Subject: Nyton Stables AL/60/19/DOC

Simon – please find my comments below on the most recent landscape plan:

PROJECT: NYTON STABLES, ALDINGBOURNE, WEST SUSSEX	DATE:	SEPTEMBER 2018
	SCALE:	1:500 @ A1
	DRAWN: CHECKED:	CZ/AT EO
	DRAWING NO:	18307-2-103 RevC

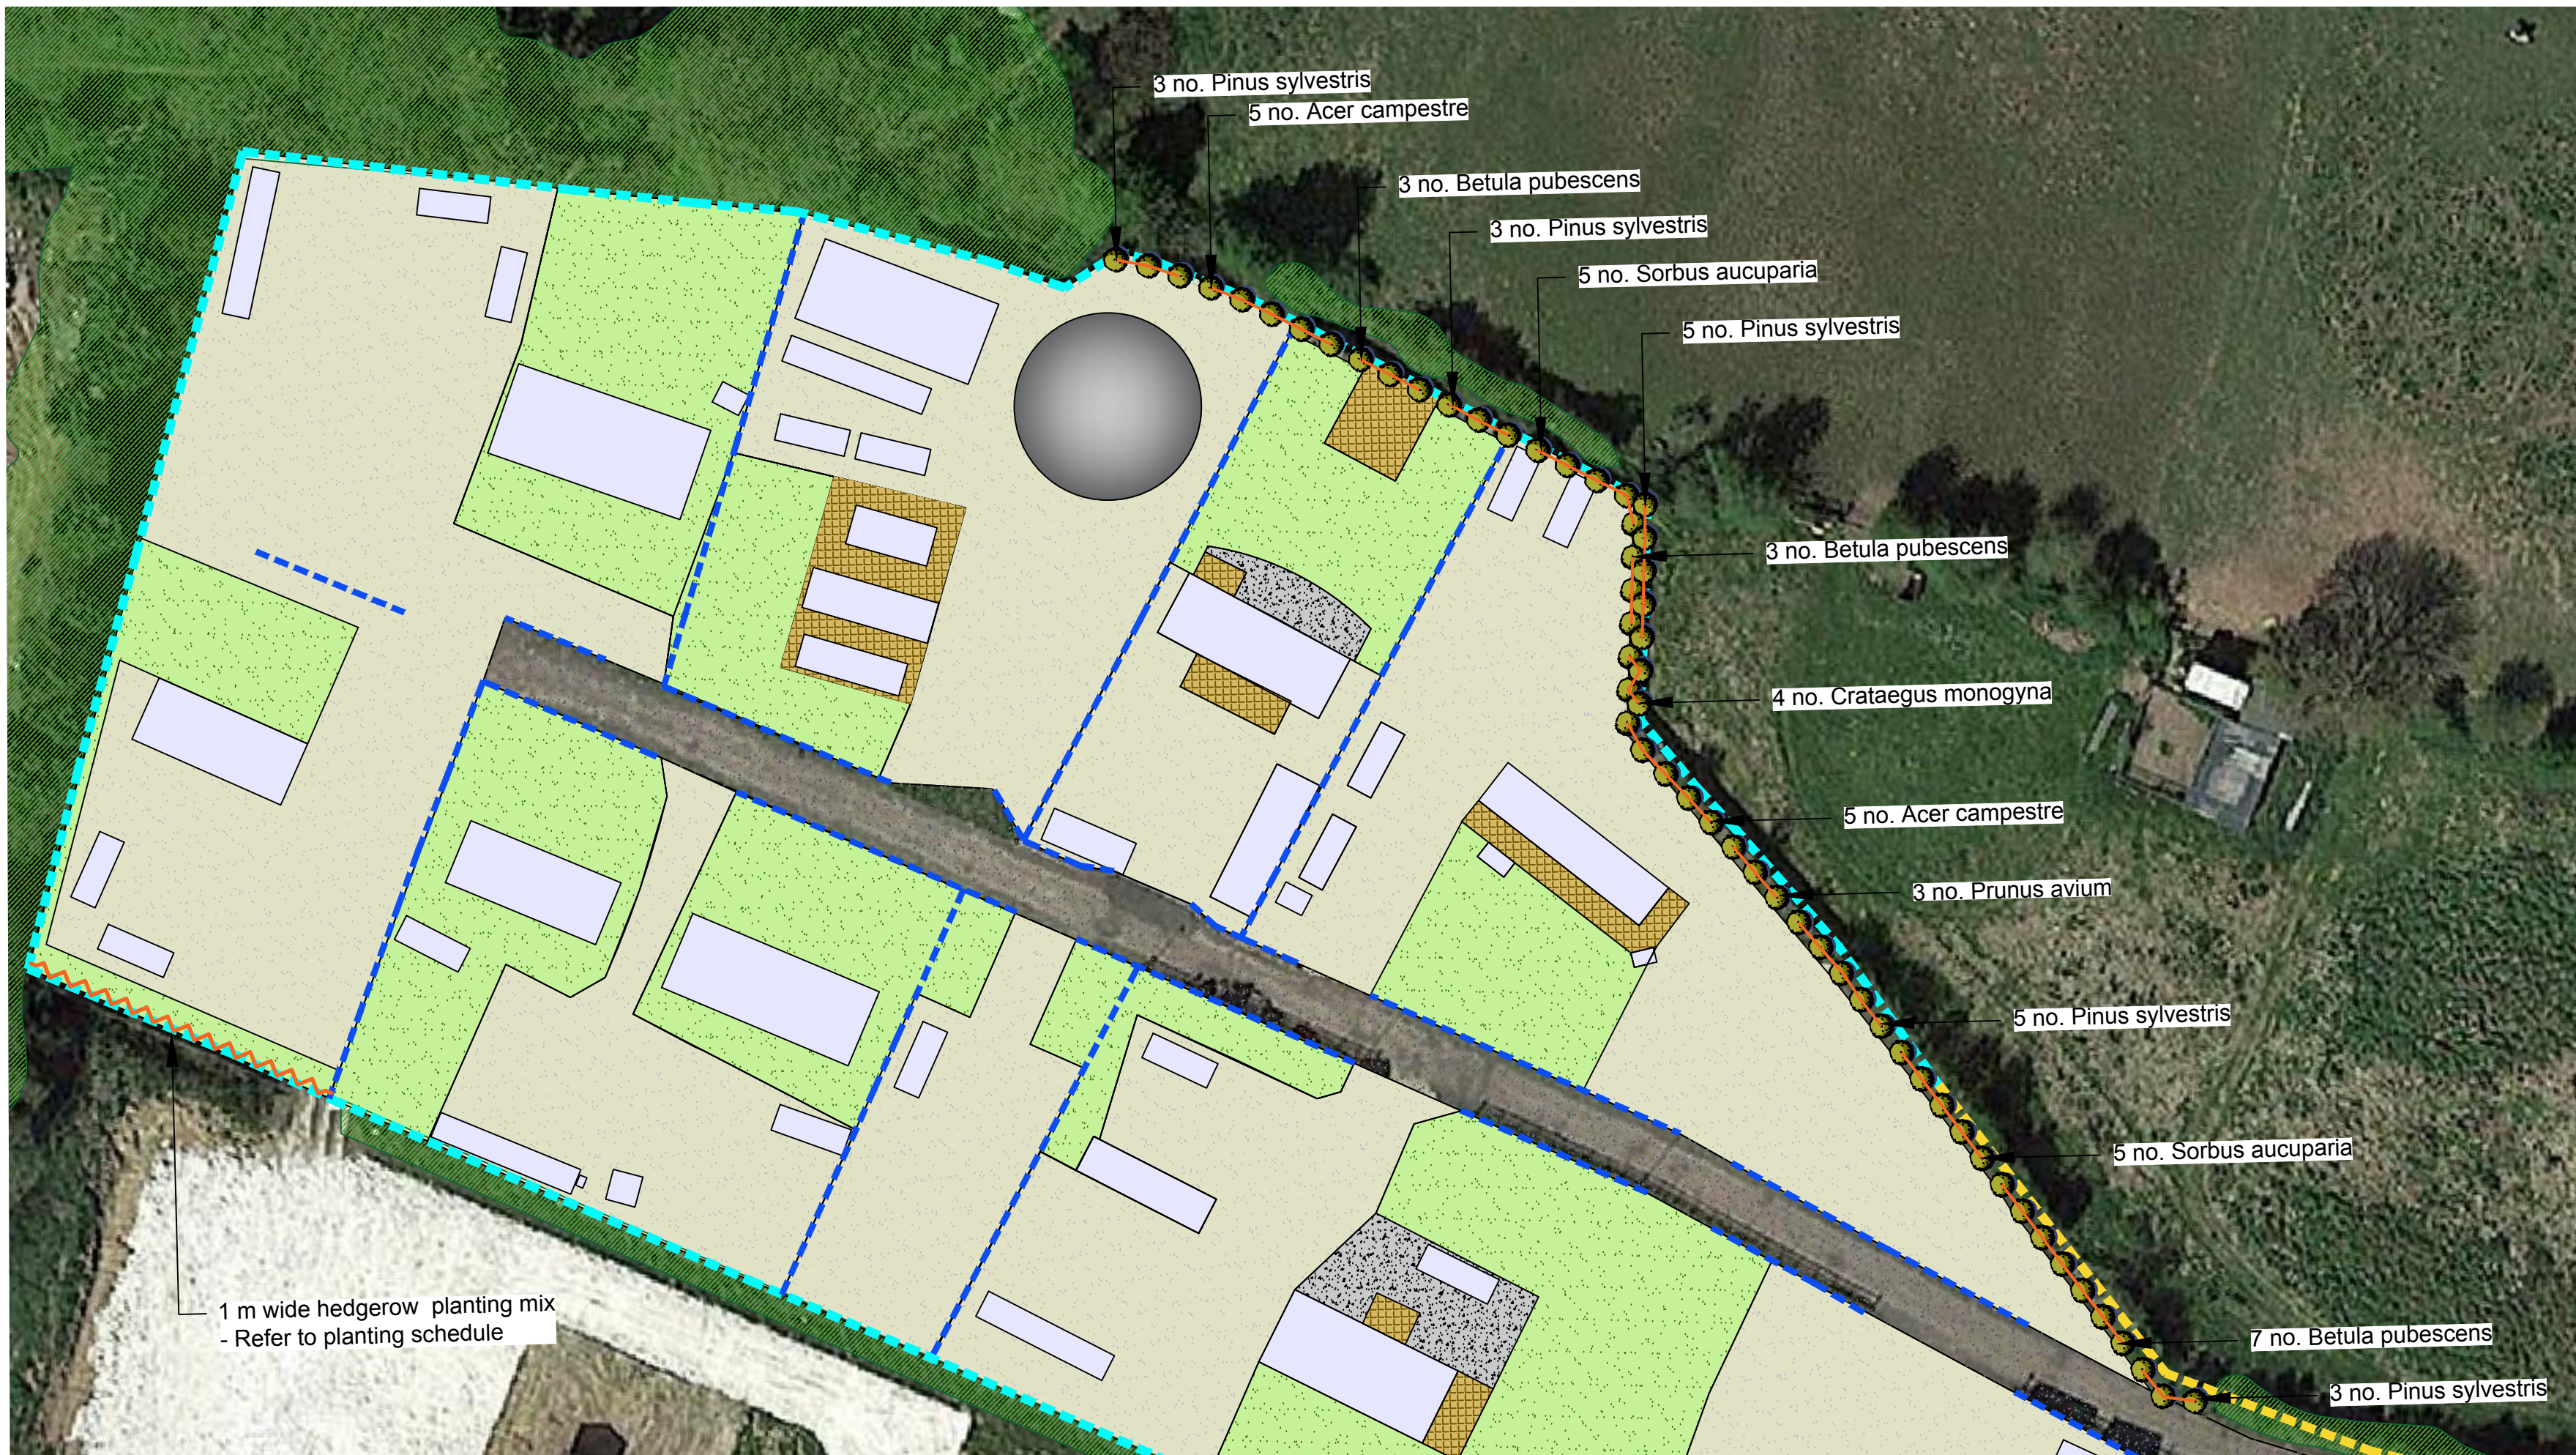
The proposed planting plan submitted follows the approval granted under AL/107/18/PL. My comments at that time sought clarity on the planting sizes of the standard trees. Previous information submitted stated that the deciduous trees would be extra heavy standards, 4-5m high when planted, with some identified as being of 18-20cm in girth. On the new plan the deciduous trees are now proposed to all be 10-12cm, a size reduction which will have a lesser impact when planted.

I had originally understood that there would be hedge planting included on the northern boundary. This together with the row of previously planted trees and the row of proposed trees would provide a good screening solution in the long term. My approval of the former plan was based on this interpretation. Having now reviewed colour versions of both plans I note that it is only proposed to plant one row of trees. Hedgerows with trees planted within them however are characteristic of the landscape in the area and a combination of hedge and tree planting is required to provide the best screening outcome on the northern boundary. The height of the trees is important in early years to filter views, but the density of the hedgerow planting is essential to screen at a lower level as the trees mature. I would therefore expect to see hedgerow planting included along the northern boundary in the areas where there is little vegetation.

I am aware that the applicant intends to provide additional planting along the west end of the northern boundary, adjacent to the public footpath. This needs to be shown on the landscape plan so there is a clear record of that intention. Some of the formerly planted trees have failed in a number of locations and must therefore be replanted. Please can it be indicated on plan where these are to be added. I also reiterate that any planting must be well maintained in order to achieve a successful scheme.

- includes native hedge planting on the north boundary
- increases the planting size of the standard trees
- identifies where failed trees will be replaced
- shows the intended planting which will screen views from the public footpath
